February 4, 2026

**RE: SWQ-2025-00051 Comments/Responses #3
U-Haul Self-Storage
8200 Jefferson St NE, Albuquerque, NM**

28816 ESC COVER

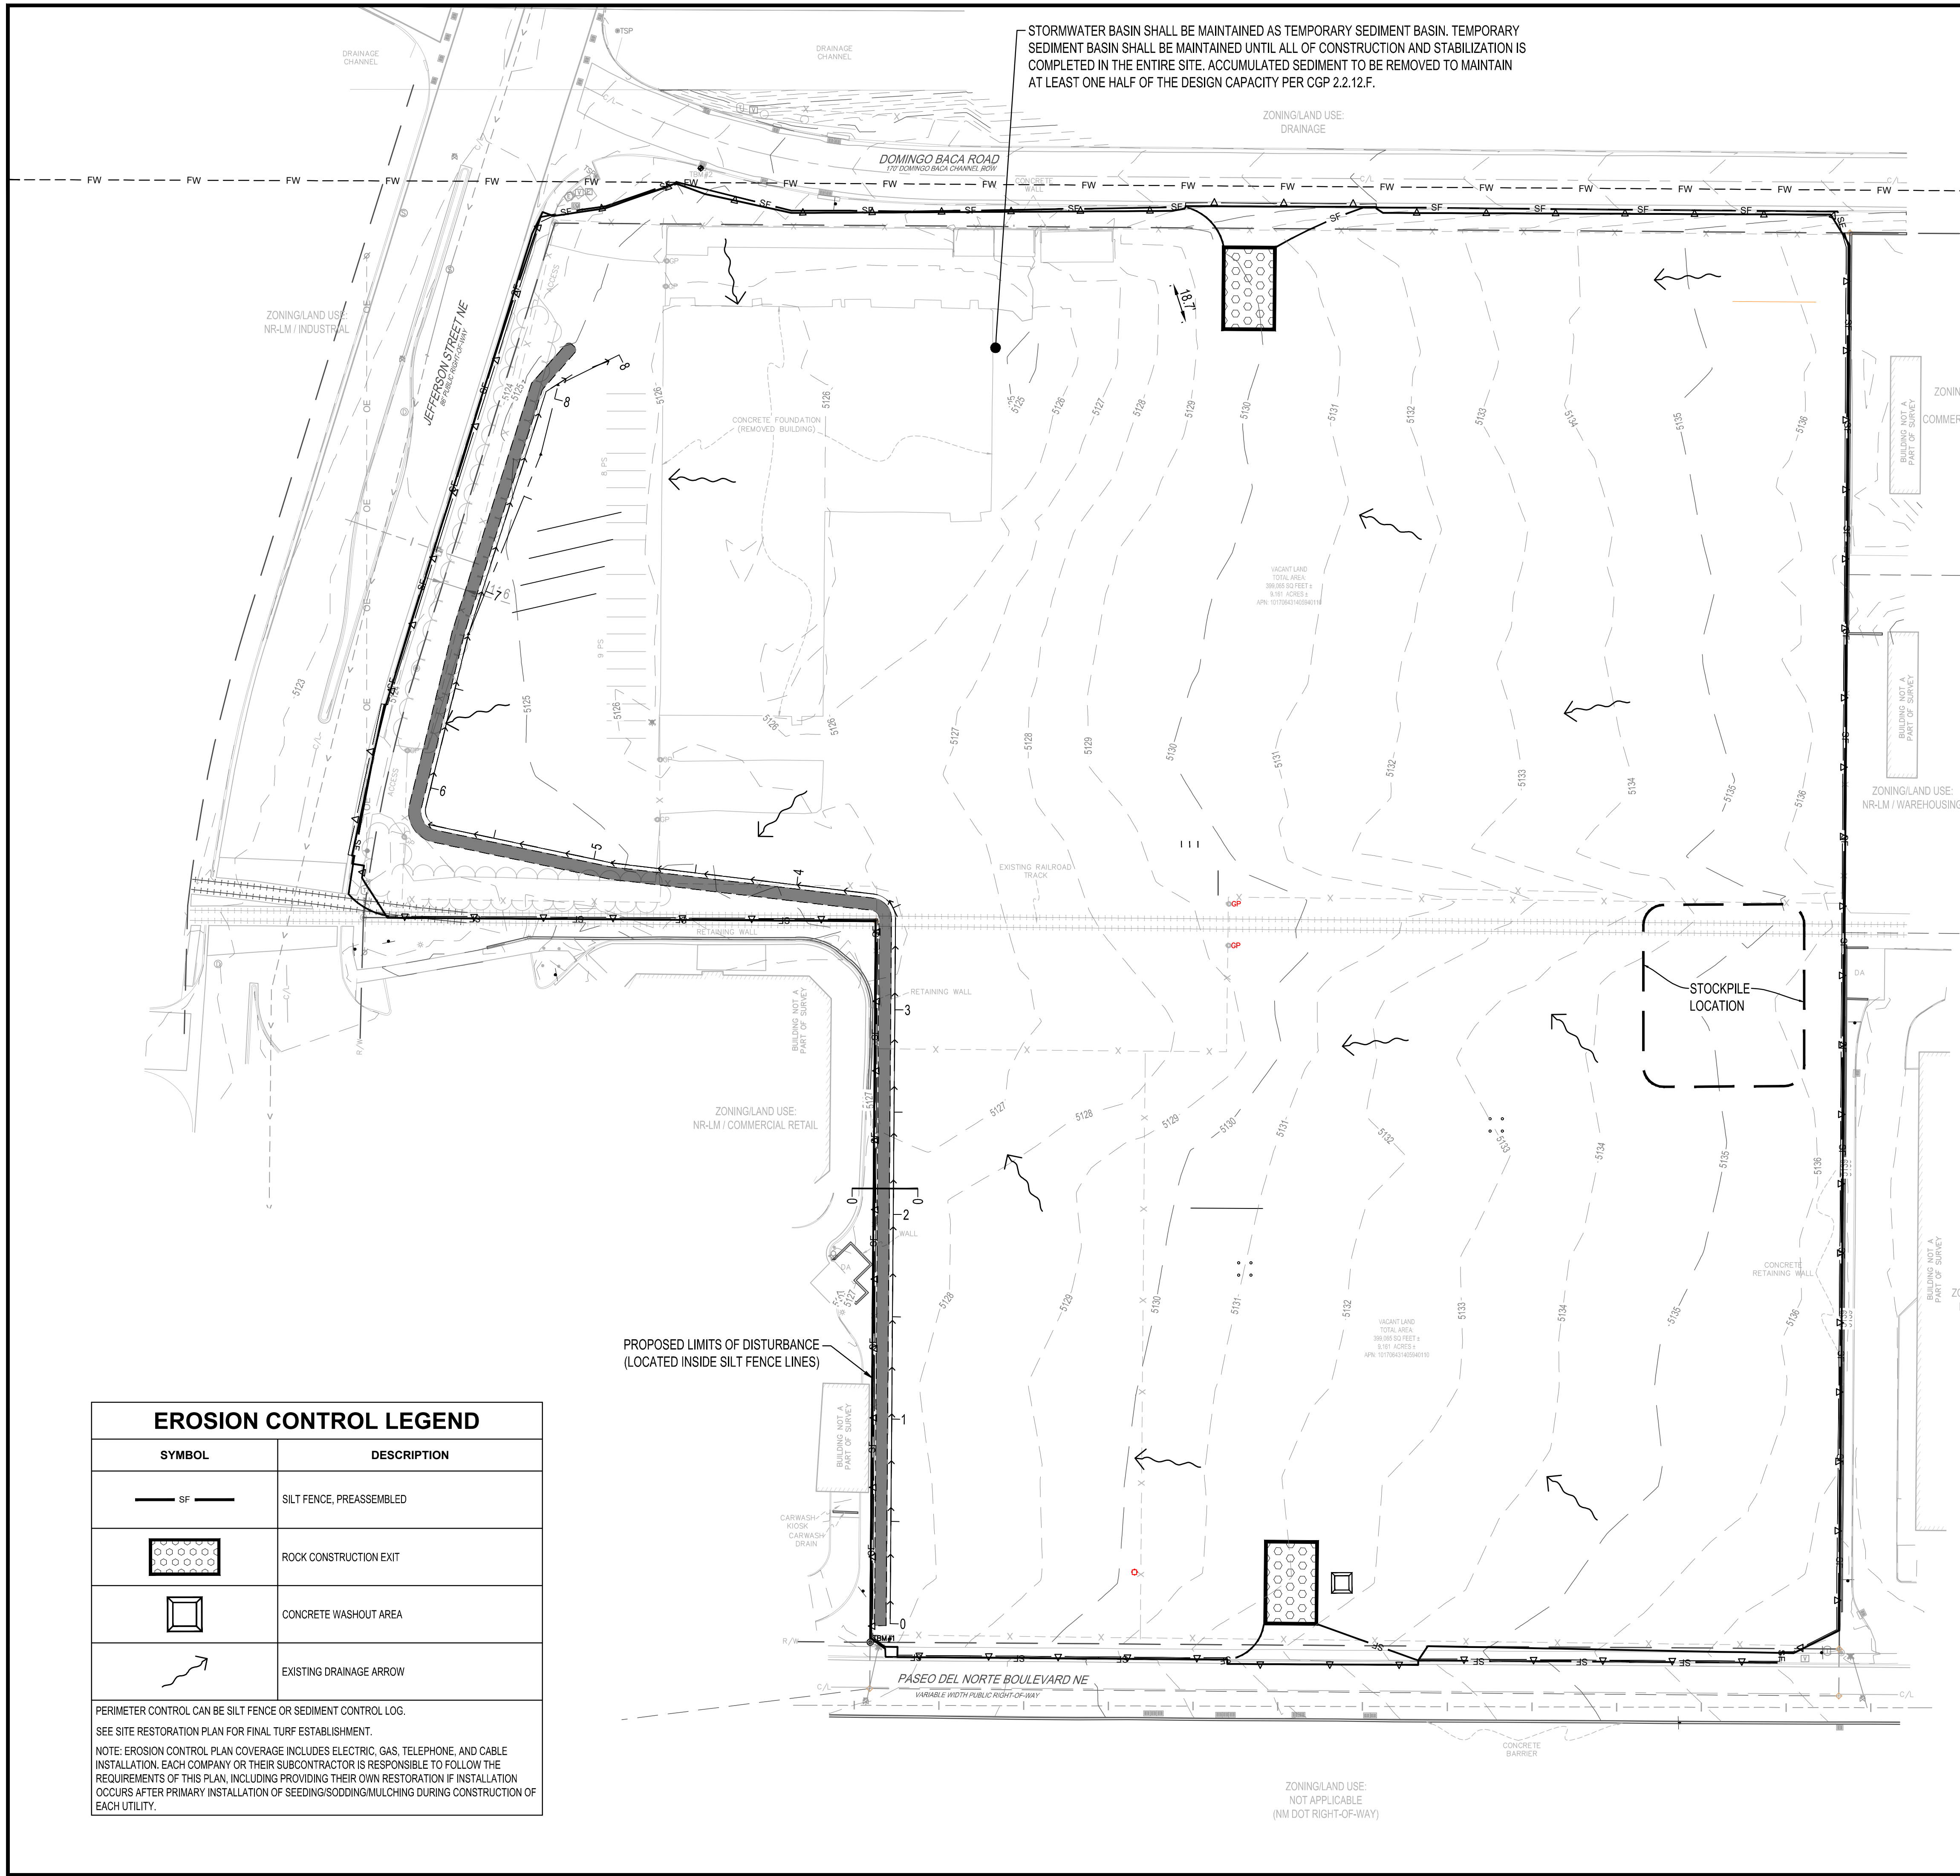
2. The sequence on the cover sheet should clearly state that the temporary northwest Sediment Basin (SB) and Diversion Channel (DC) are the first items of construction, before any land disturbance begins. Currently, it mentions site demolition, clearing and grubbing, and over-excavation of building pads before referring to the “cutting of the designed permanent retention pond.” The sequence also does not specify operating a temporary SB before or during construction. It must explicitly indicate that BMPs, including the temporary SB and DC, are installed first, prior to any land-disturbing activities, and differentiate between the temporary and post-construction versions of the pond. Additionally, it should state that these temporary controls require inspection and maintenance until construction is complete, stabilization is achieved, and the temporary BMPs are replaced by the post-construction SWQ ponds approved by hydrology.

ISG Response: This has been noted and updated to ensure the SB and DC are installed prior to any land disturbance begins and that proper inspection and maintenance shall be performed on the temporary controls until construction is complete, stabilization is achieved and temp BMPs are replaced by post-con SWQ ponds approved by hydrology.

2816 ESC 2

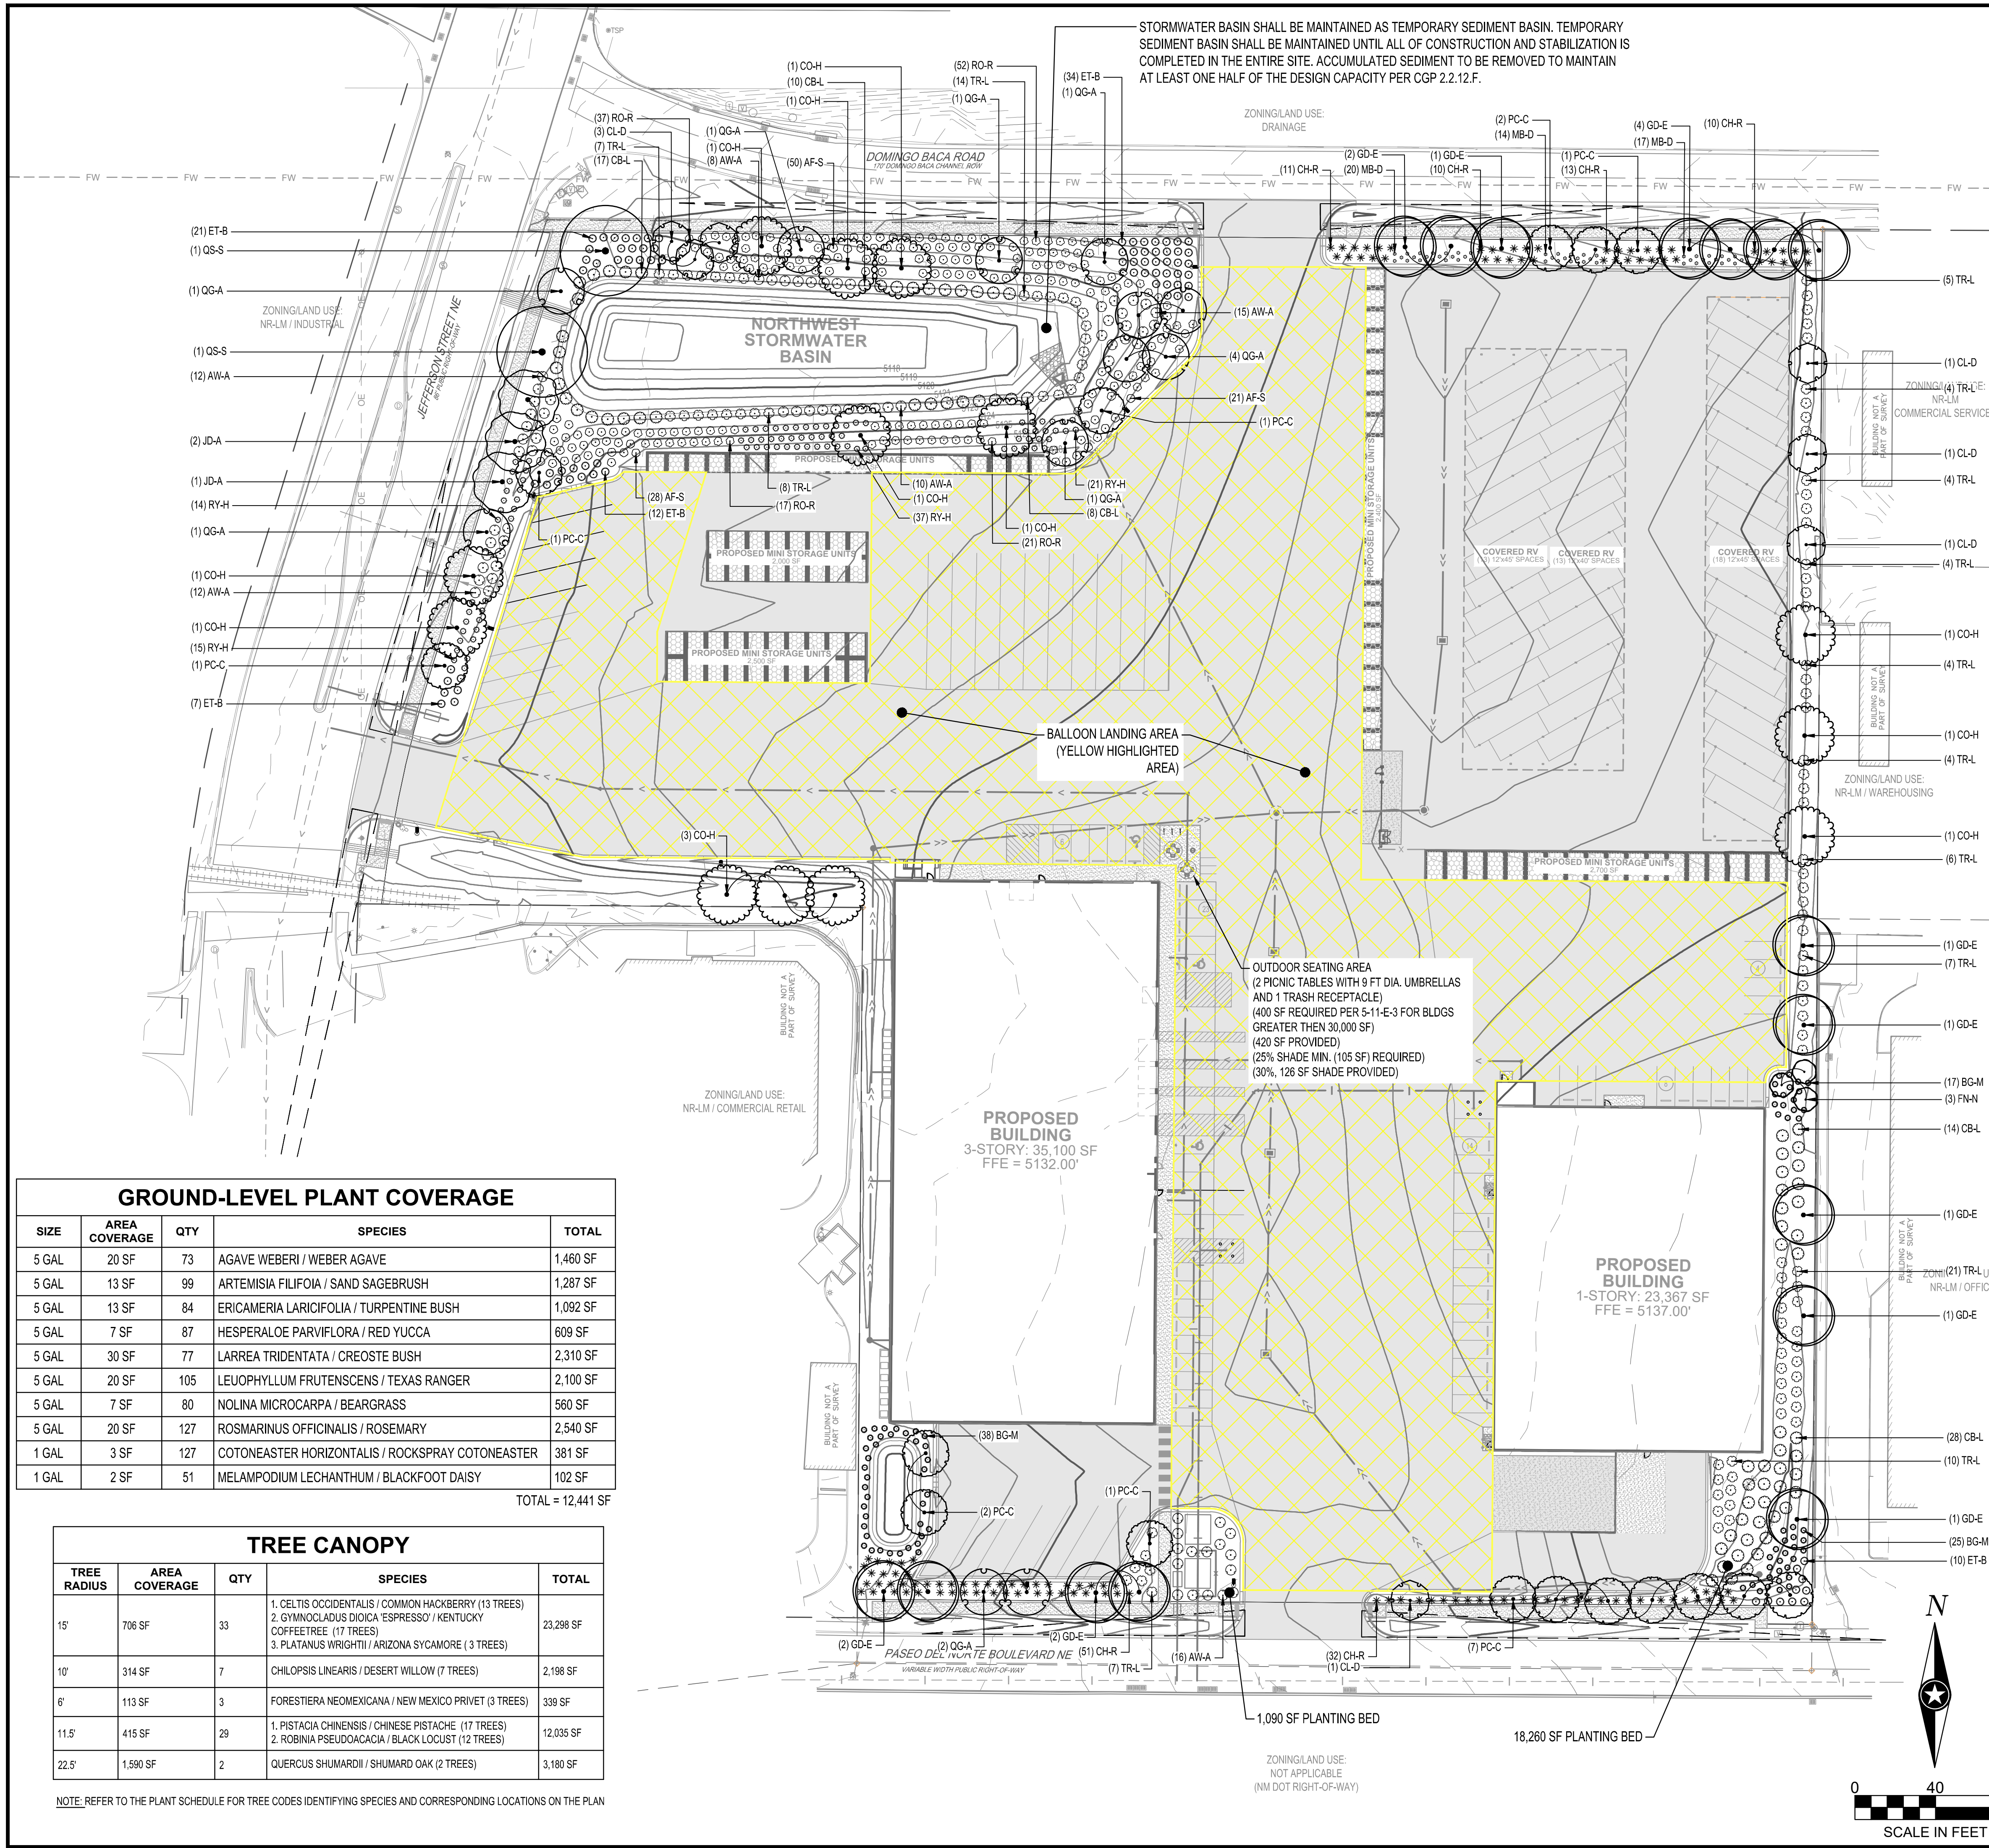
3. The note on sheet 3 about replacing the diversion channel with a storm drain west of the building appears poorly planned. Where are the inlets that intercept stormwater to replace the DC during construction? Provide locations and details of these inlets, along with the grading that will direct stormwater into the storm drain if this temporary stormwater control method is used. The storm drains should be added to the sequence and listed as one of the temporary controls on the cover page. They must be inspected and maintained, with sediment removed during construction. An alternative drainage structure on the property line west of the building should be considered instead of the temporary storm drain BMP.

5. Sheet 3 shows the same top elevation of the berm, 5128.14, at three consecutive locations west of the building, and the DC is less than 18 inches high at two of them. The lettering height of the elevations must be 0.1 inches or larger.

ISG Response: This storm drain has been better depicted on the plans with invert elevations and pipe size. This shall help carry all stormwater between the building and the property line to the west. It has also been added to the sequence of installation and temporary controls on the cover page and shall be inspected and maintained during construction.

ISG Response: This has been updated.
